Project Name: SEVEN BAR RANCH

City of Albuquerque
Planning Department
Inter-Office Memorandum

TO: Jack Cloud, DRB Chair
FROM: Randall Falkner, Planner
SUBJECT: Project # 1003658

On July 17, 2008, the Environmental Planning Commission approved Project # 1003658 08EPC-40066/40067/40068, a site development plan for subdivision, a site development plan for building permit, and a request to amend site development plan for building permit for Tract D-4-G, Seven Bar Ranch, zoned SU-1 IP, located on NM 528 between Ellison Drive and Corrales Road, containing approximately 9.3 acres.

NORTH ELEVATION

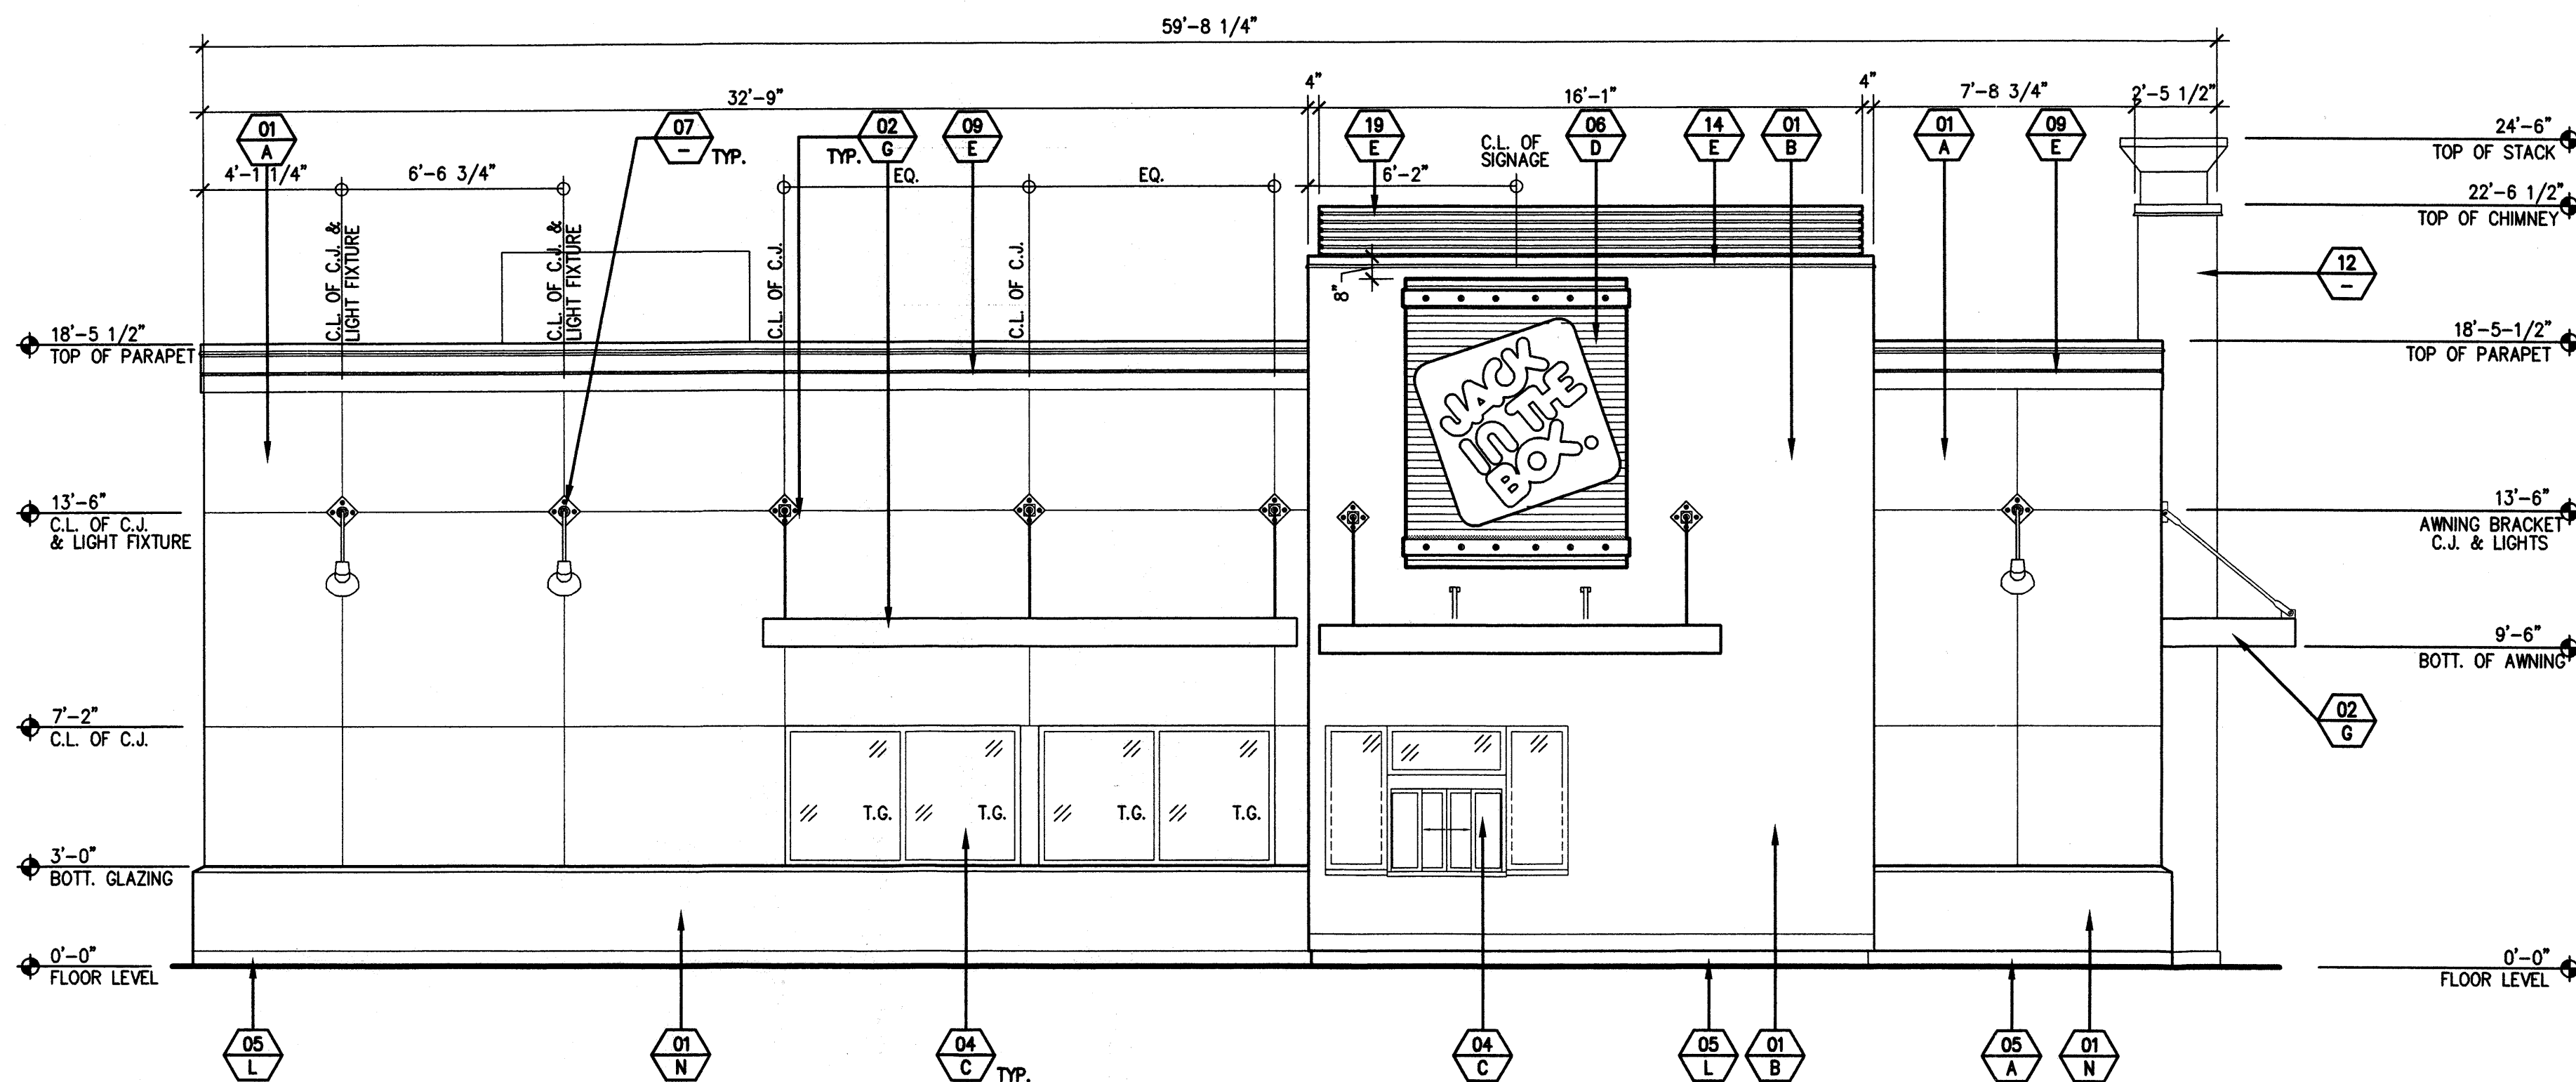
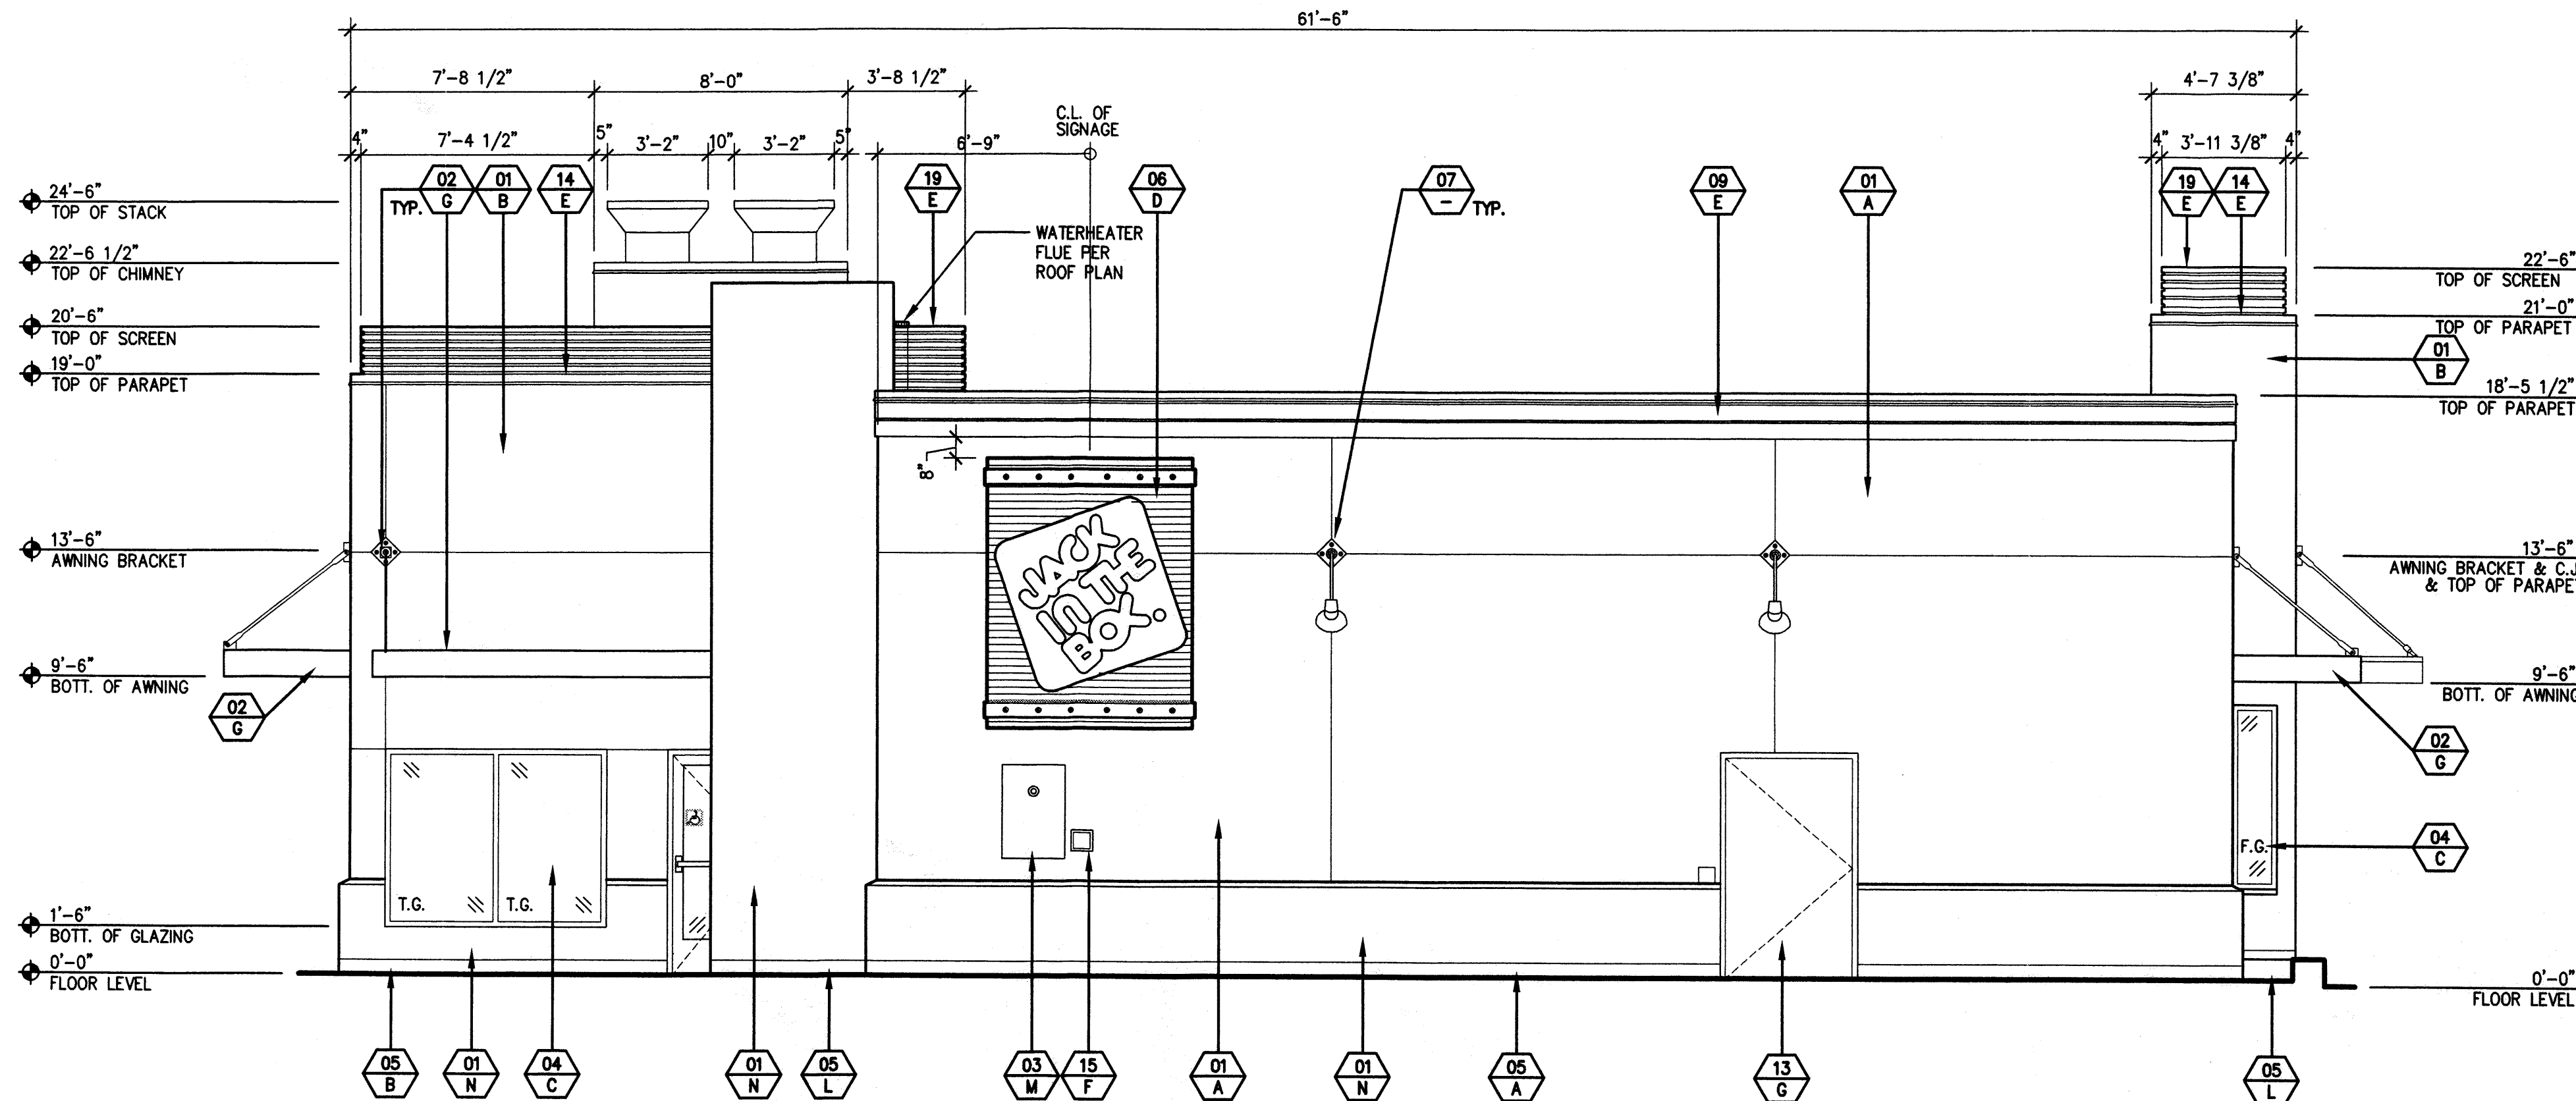
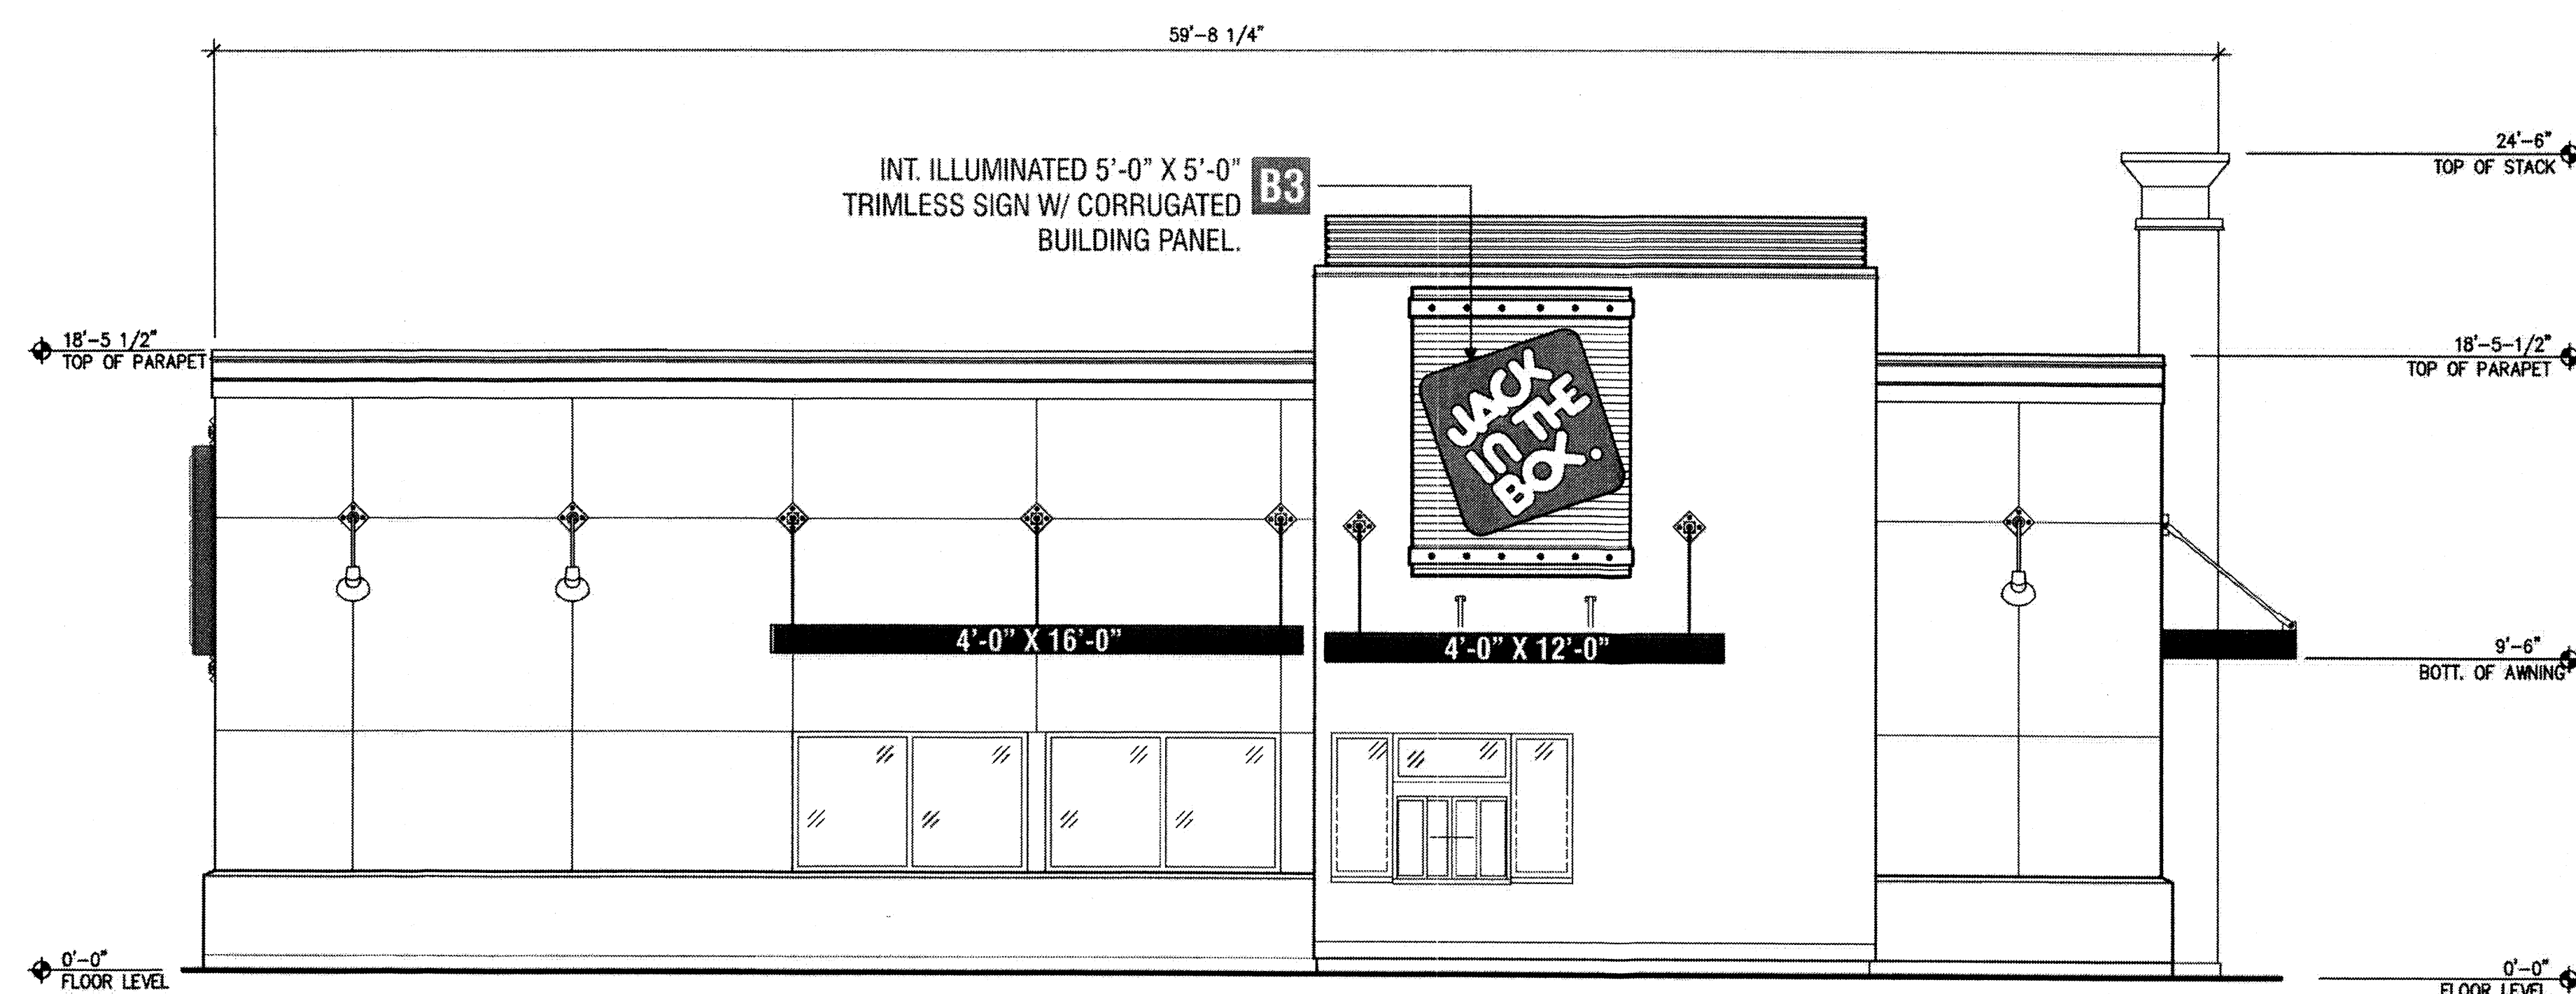
Sheets 3 and 4 in the final submittal are the same Sheets with the same elevations (south and west). One of the Sheets should contain both the north and east elevations.
